From: Martyn Parr <[REDACTED]>
Sent: 13 July 2021 14:34
To: Alec Philpott
Cc: Steven Lecocq
Subject: RE: Yapton

Reference attached, WSCC asked that we consider some tweaks to the site access at Yapton. They also asked that those changes (attached) are *"run past our RSA team"*

ACCESS ROAD LAYOUT

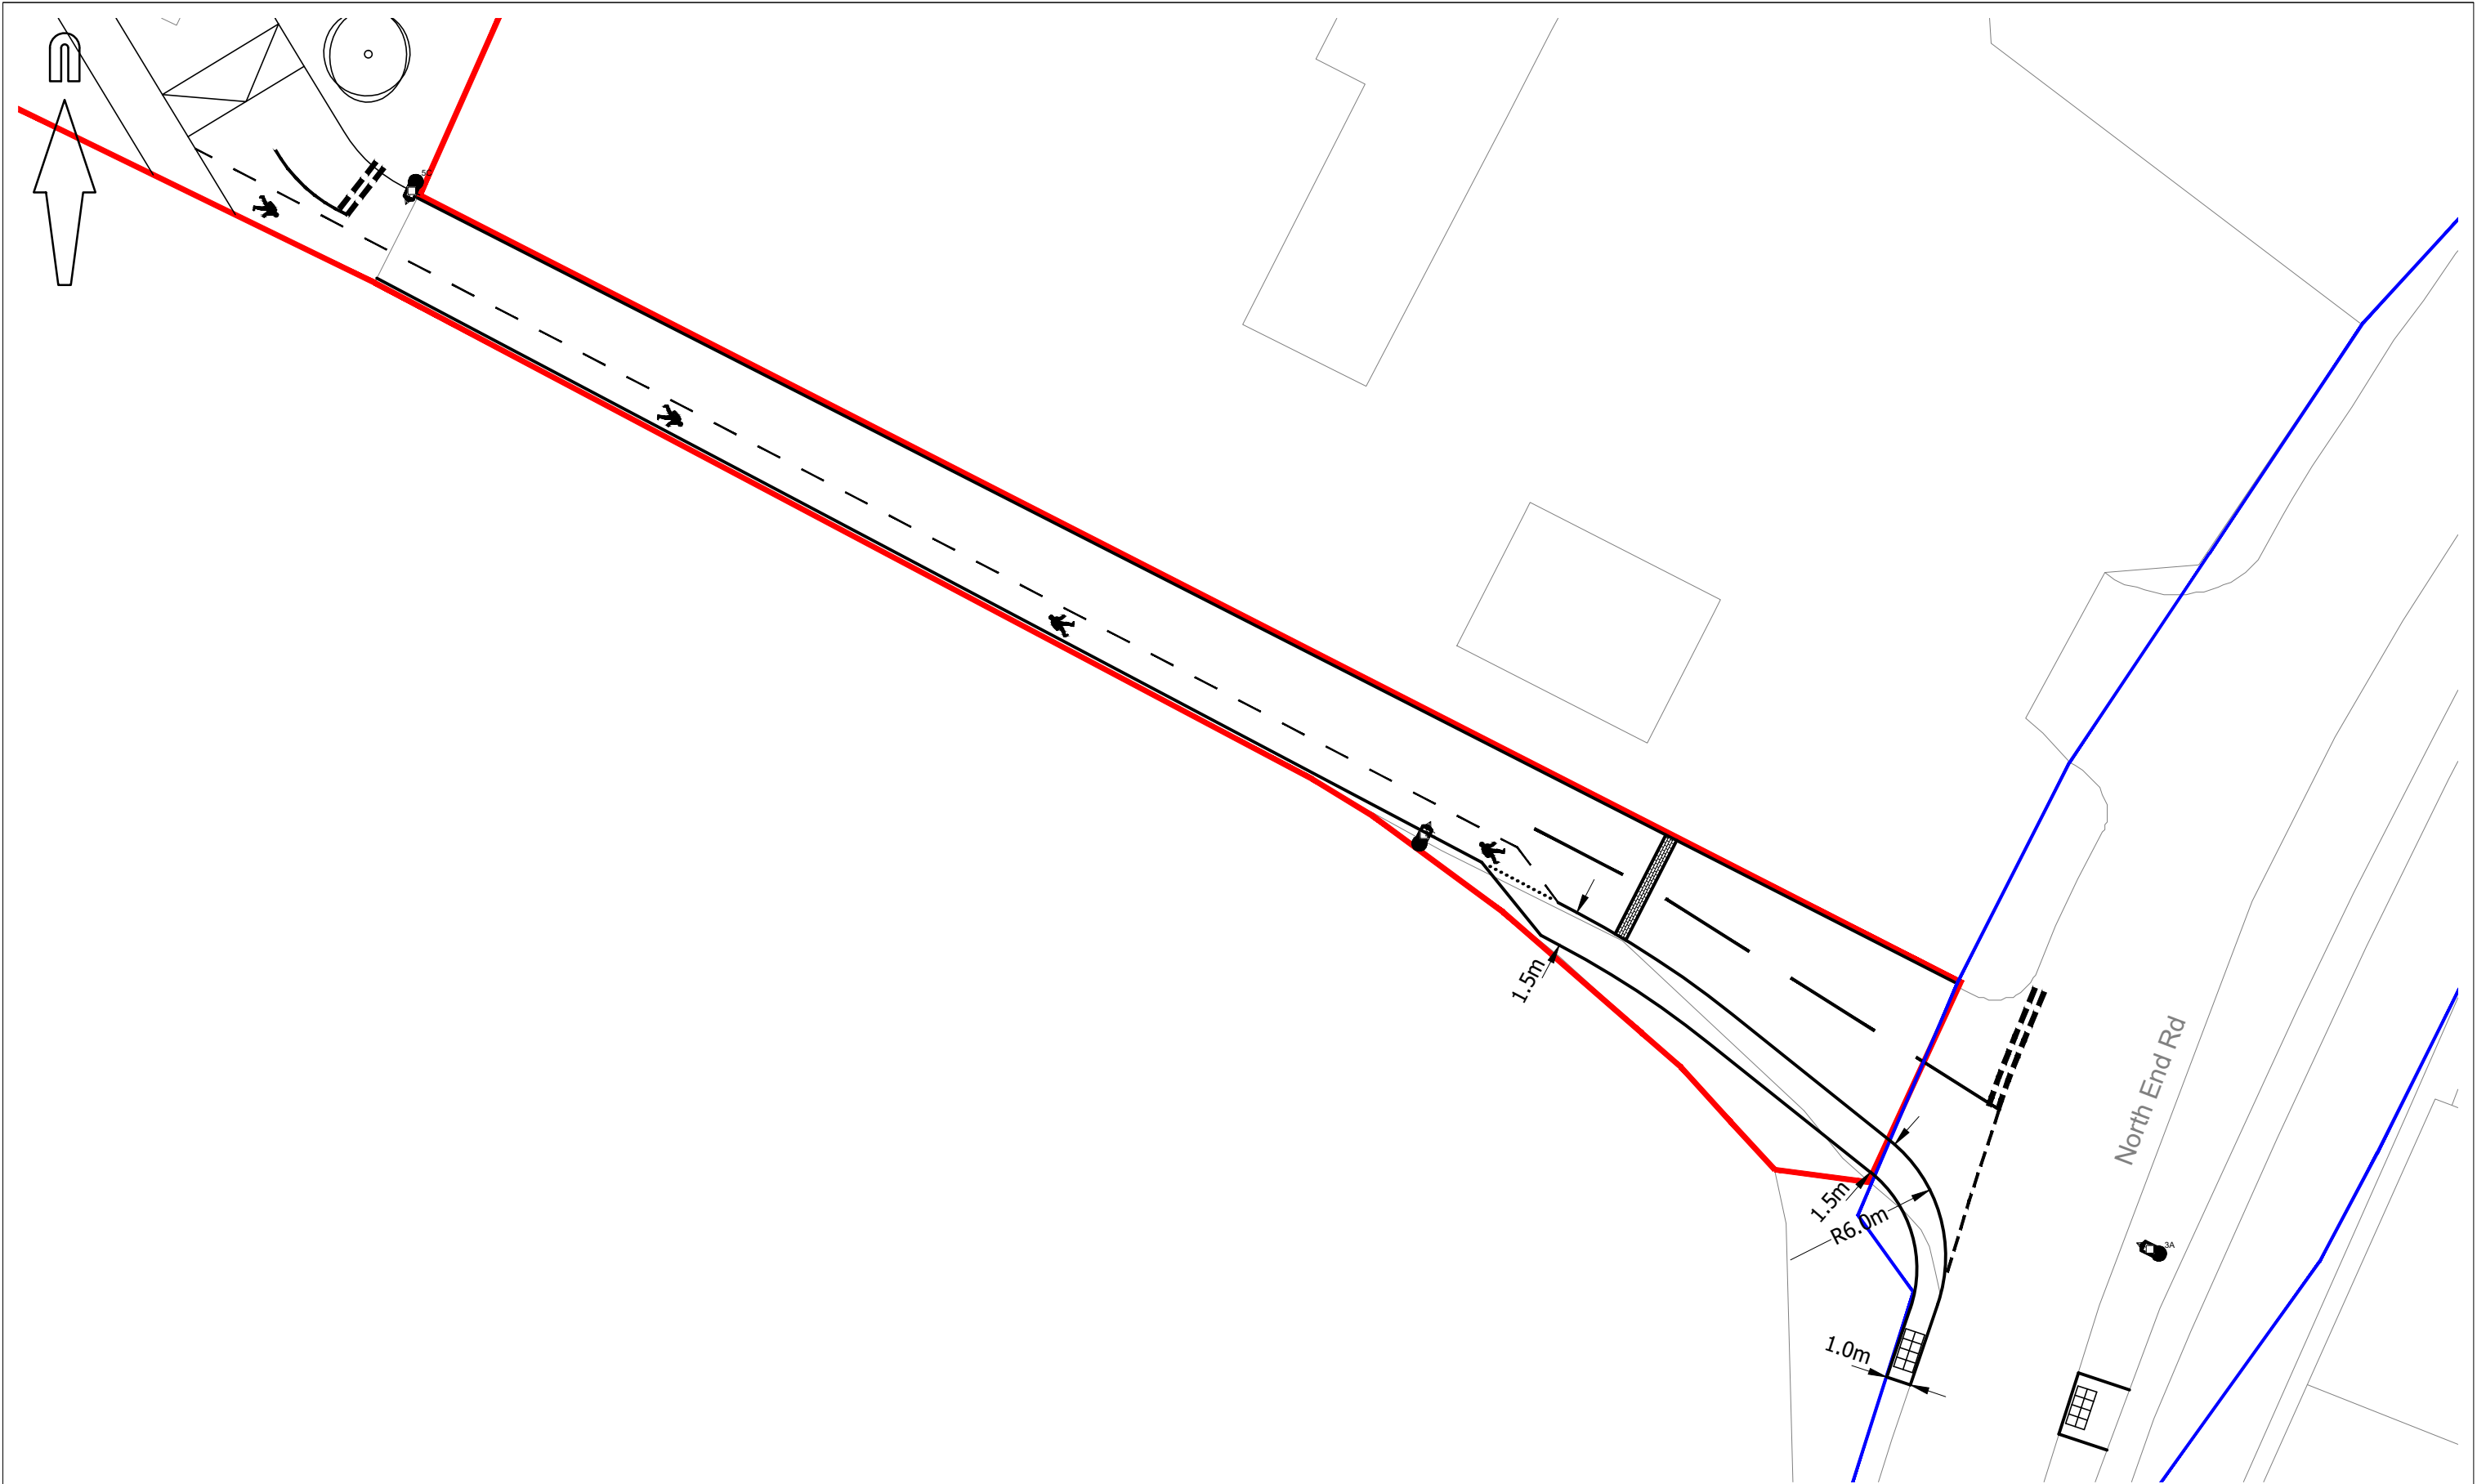
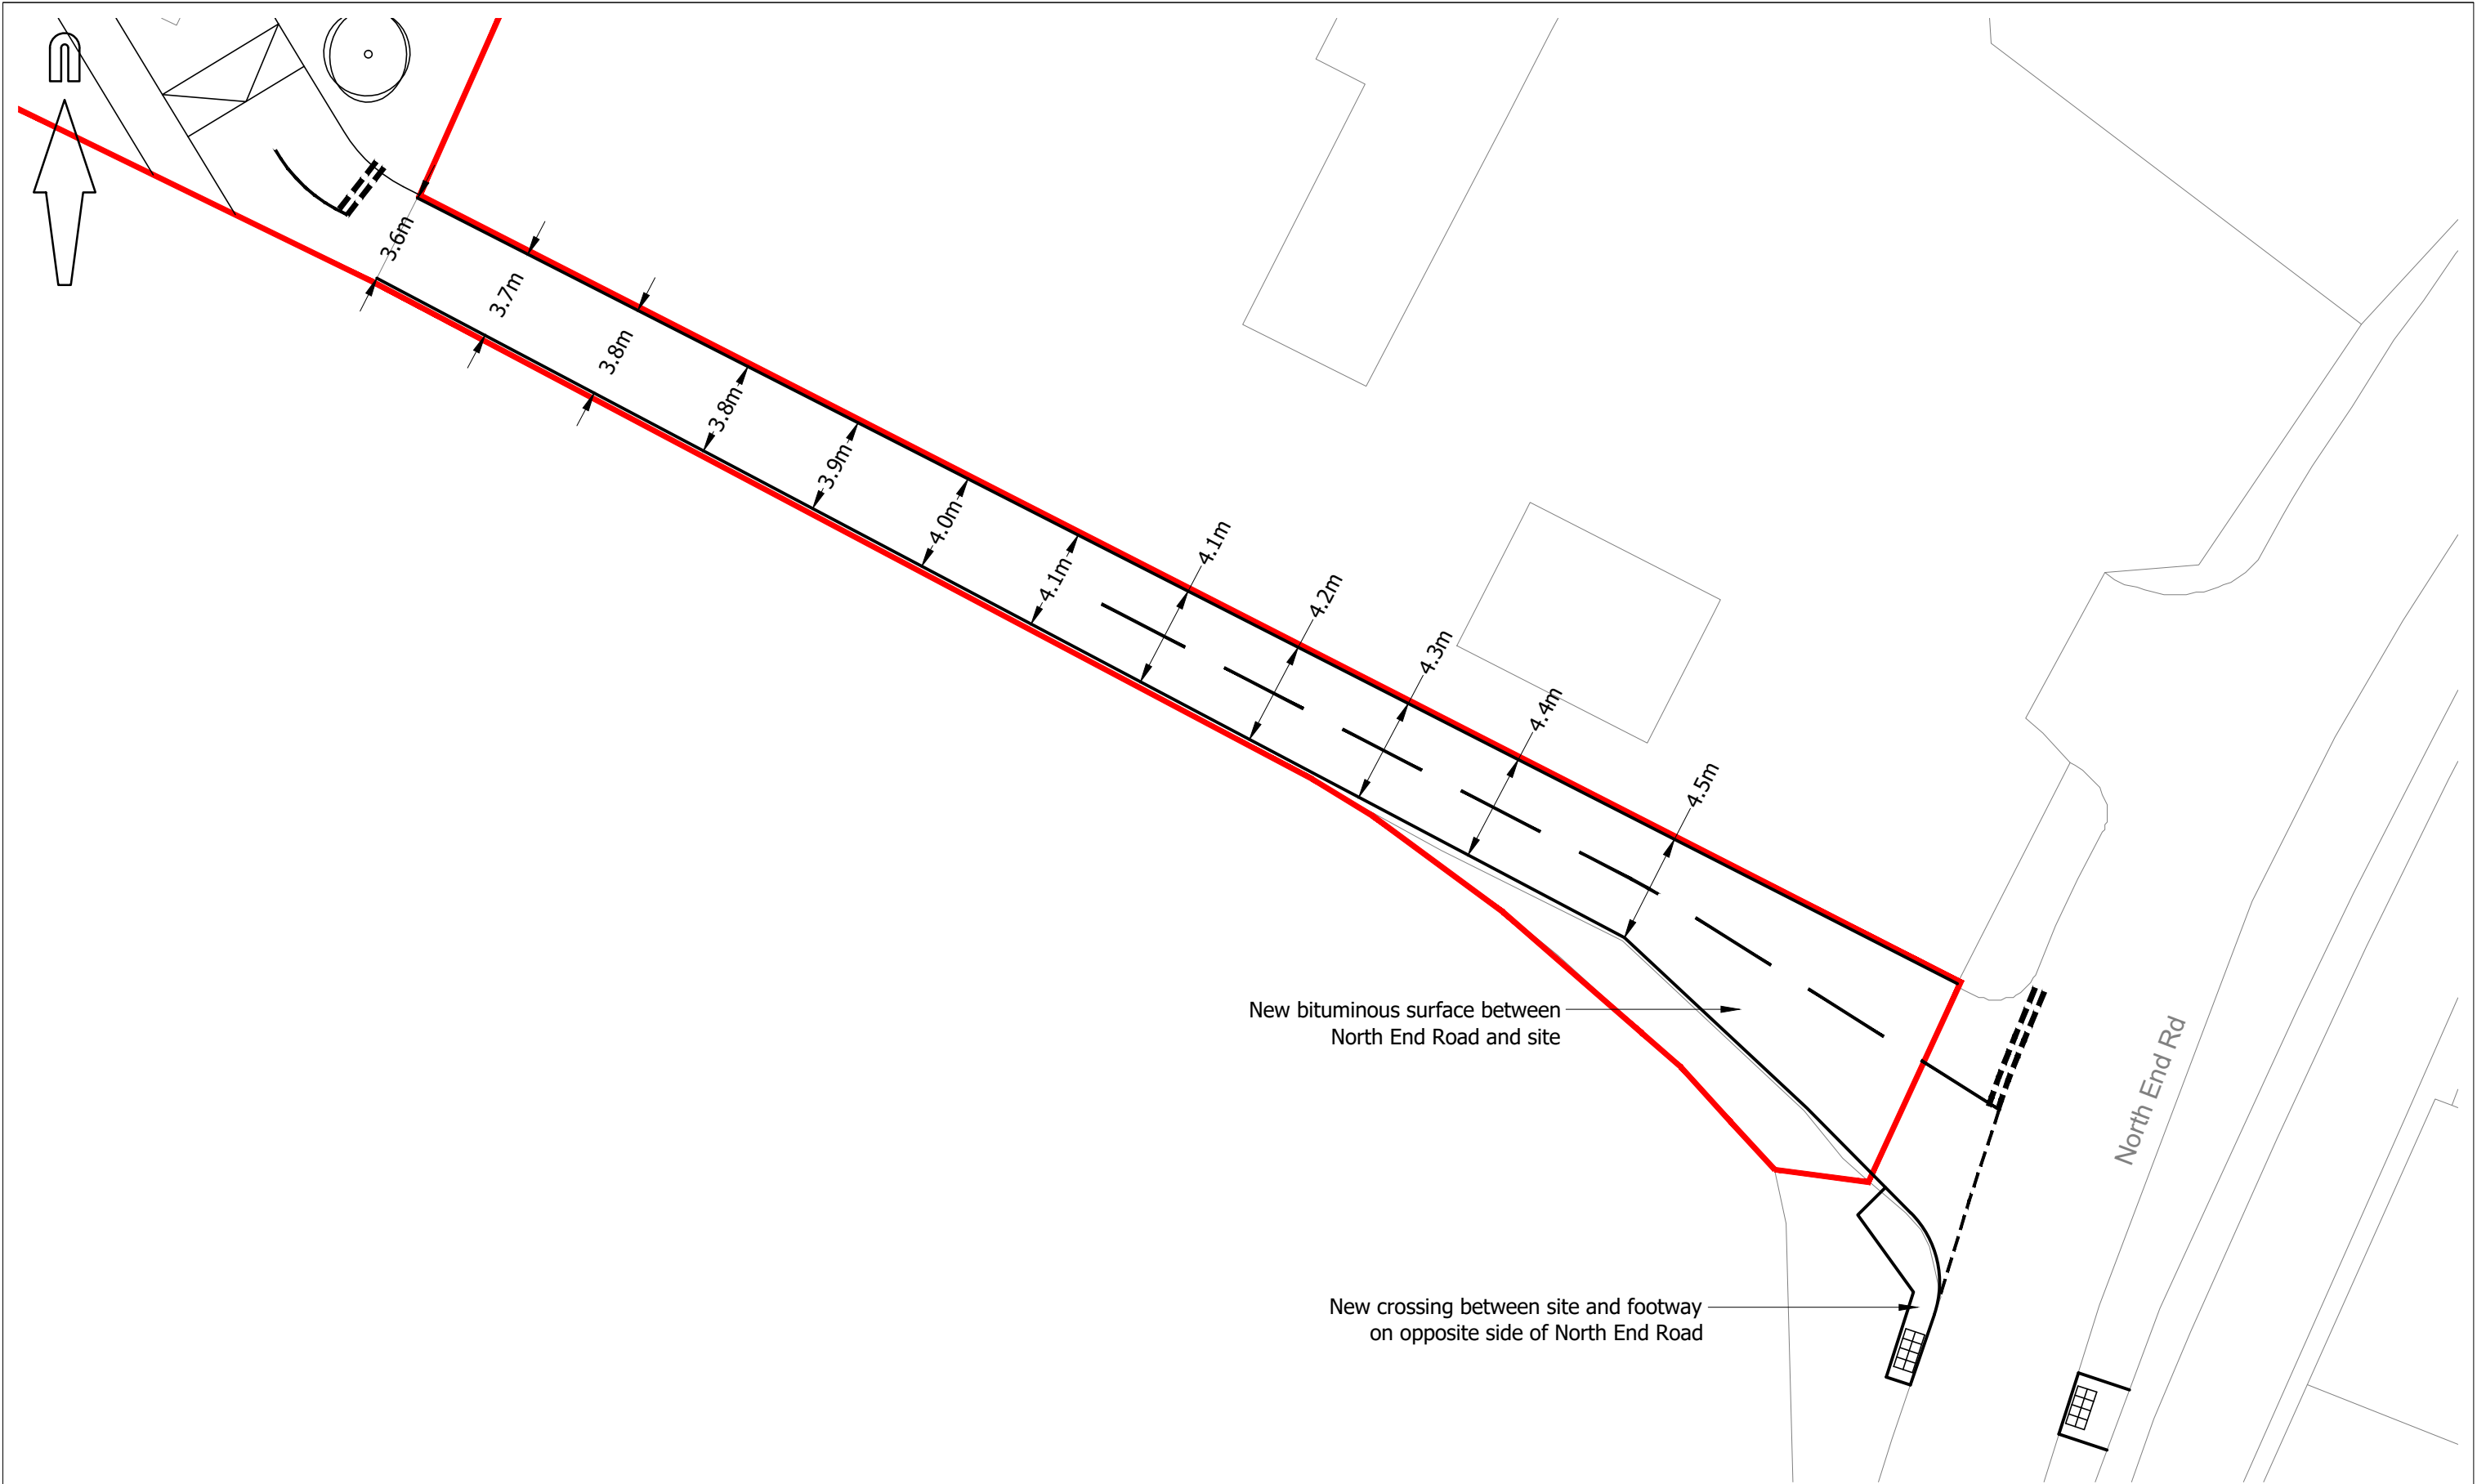
In my original email I asked that you run any changes past your Road Safety Audit team. If you've not done this already, please would you do so as a matter of priority to see what they have to say about the changes. Please send me their reply/ies.

This incorporates your suggestion to shift the bellmouth slightly further north to allow for a revised pedestrian footway. The plans also show a rumble strip and white lining to indicate pedestrian movement, as requested.

The Audit Team consider that no material increase in risk to road users will arise as a result of the latest proposals.
